Your Ref  
LU/239/11/DOC  
Our Ref  
S/AR/2011/239  
Date: 25/08/2011

Proposal: Application for approval of details reserved by conditions 5, 6, 7, 8, 9, 10, & 13 of previously approved application LU/93/10.  
Site: Wickbourne Swan, Clun Road, Wick, Littlehampton, West Sussex BN17 7EQ.  
LU/239/11/DOC

CLIENT	PMC		
ARCHITECT	D84 ARCHITECTS		
JOB TITLE	CLUN ROAD, LITTLEHAMPTON		
DRAWING TITLE	SITE LAYOUT DRAINAGE AND LEVELS		
SCALE AT A1	DATE	DRAWN	LF
1:100	DEC 10	LF	LF
	DN5	CHECKED	-

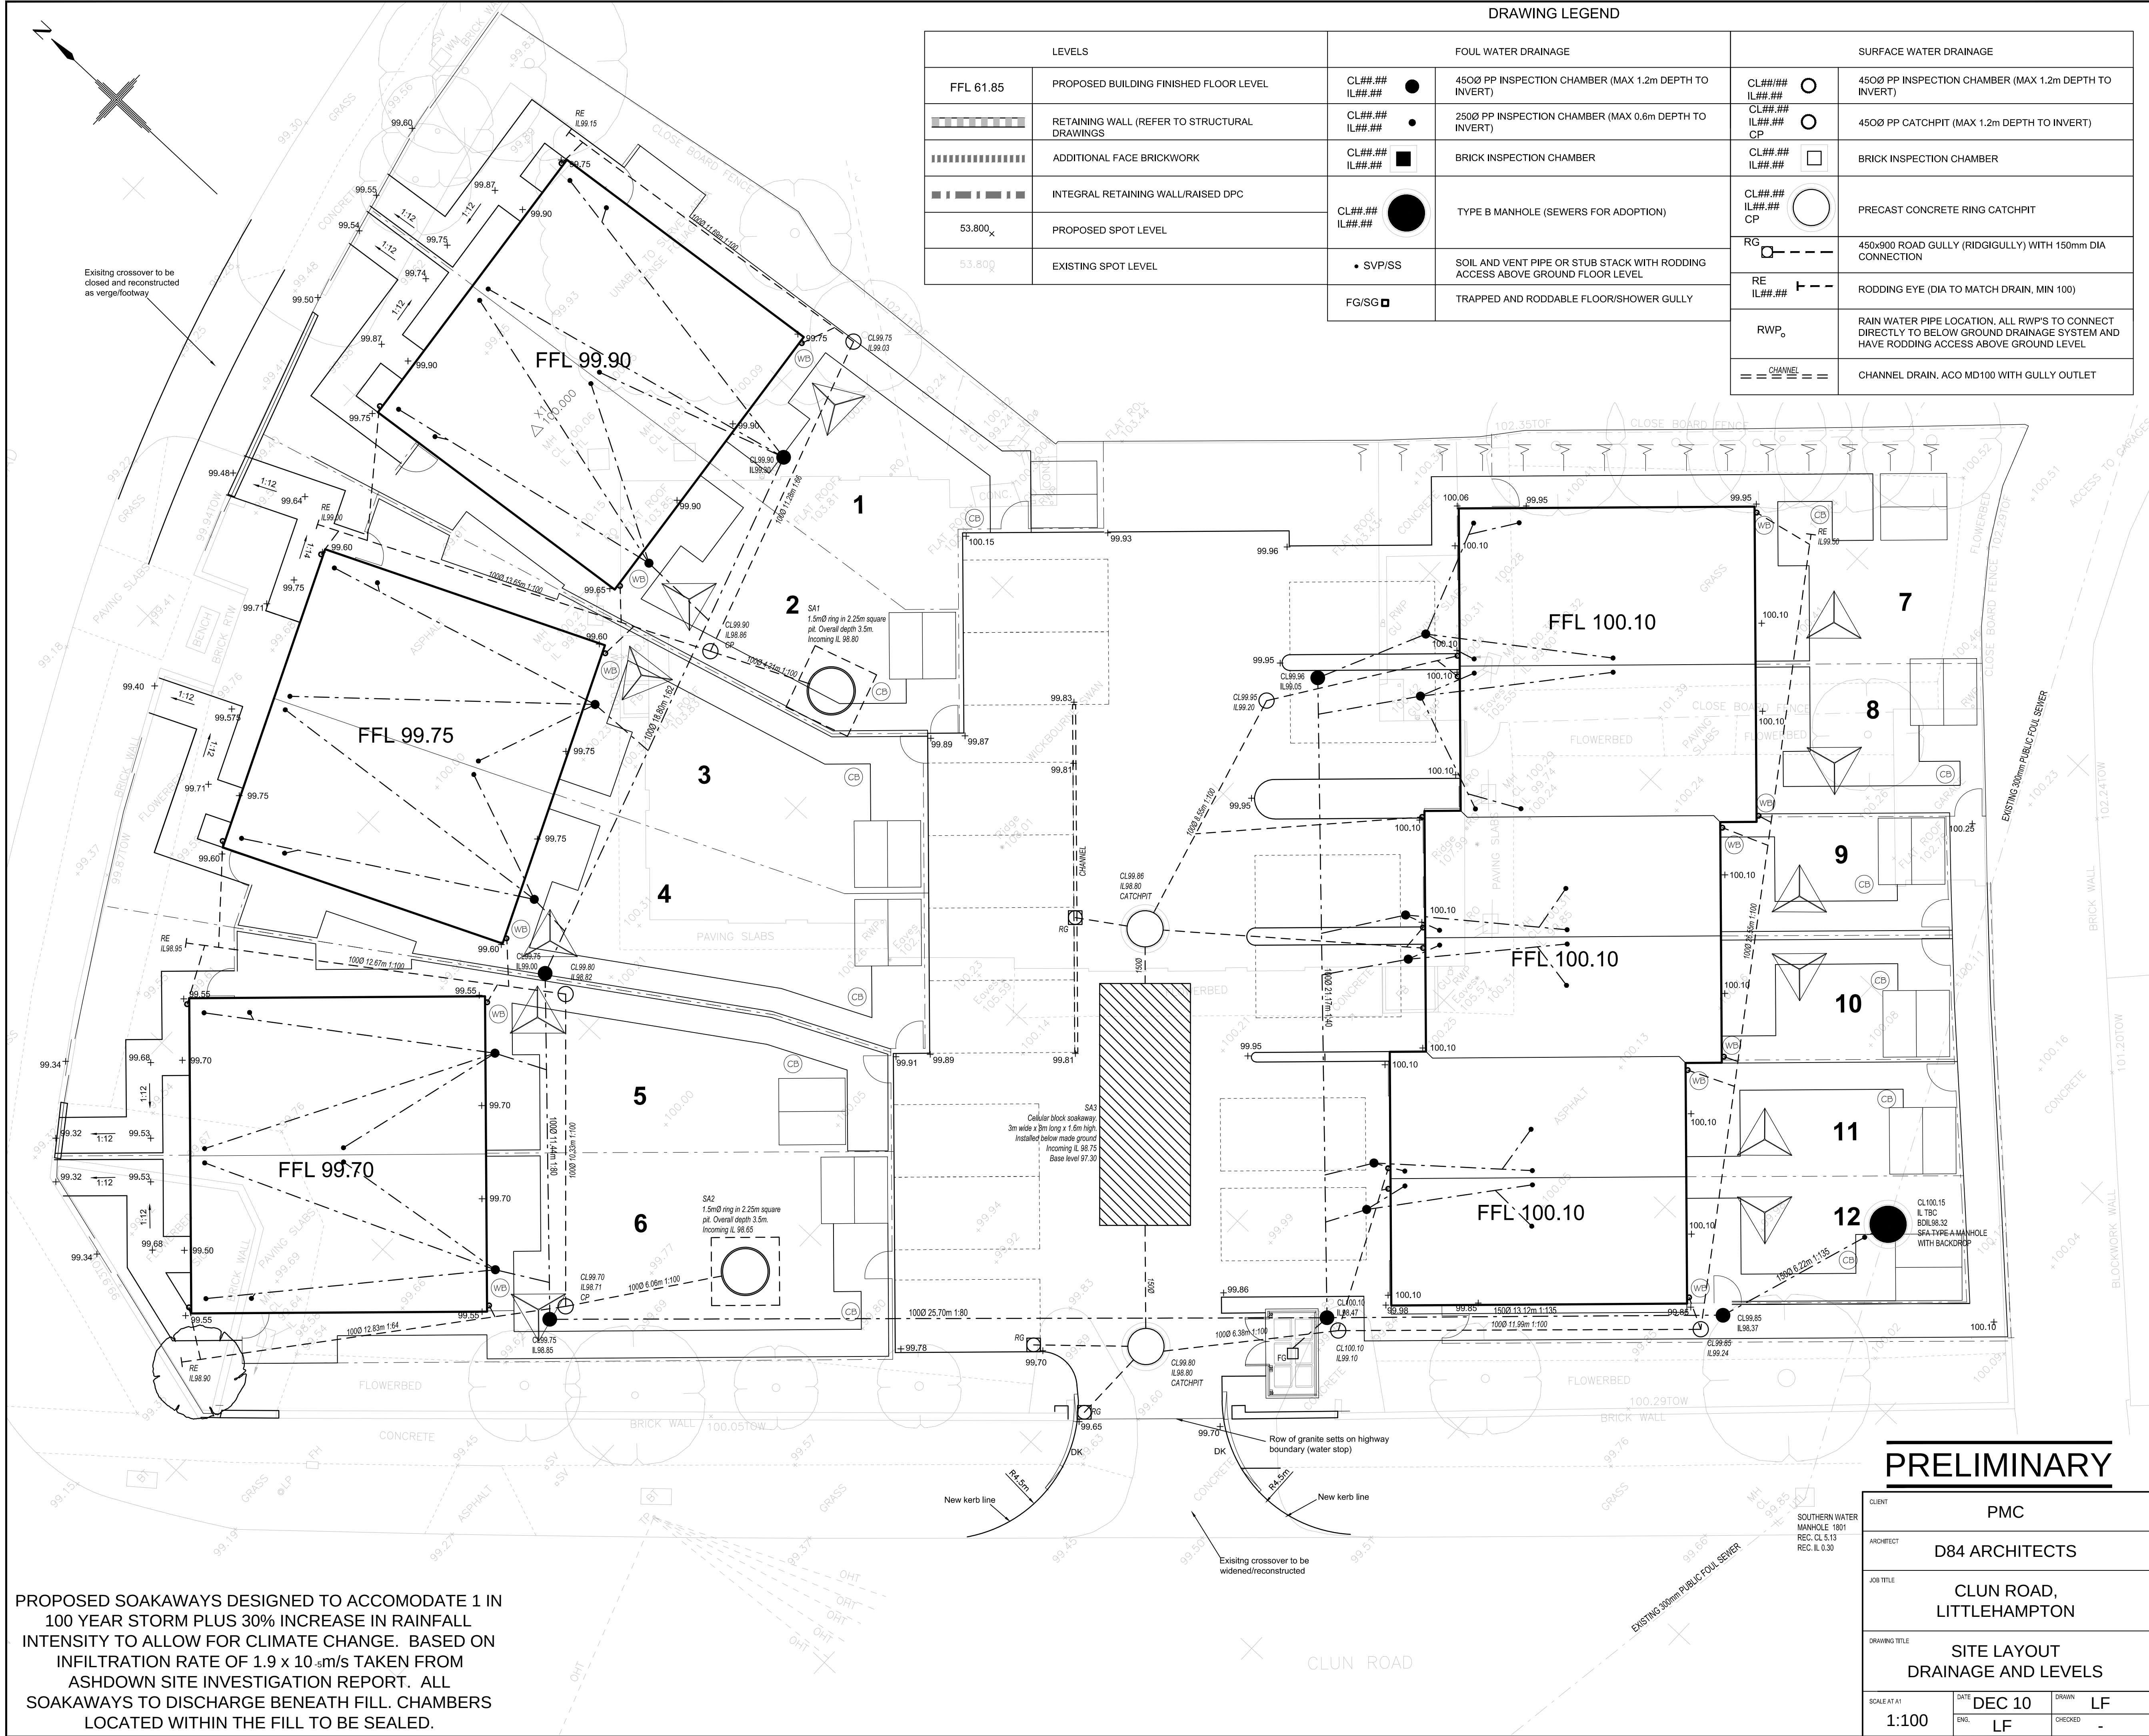
We are happy to confirm that the proposed foul drainage details are acceptable to Southern Water and we would recommend discharge of the condition 13. However, a formal application for connection needs to be submitted and approved by Southern Water.

The use of soakaways for surface water disposal would be satisfactory to Southern Water and we would recommend discharge of the condition 13. However, The Council's Building Control officers/ technical staff or Environment Agency should be asked to comment on the adequacy of soakaways to dispose of surface water from the proposed development.
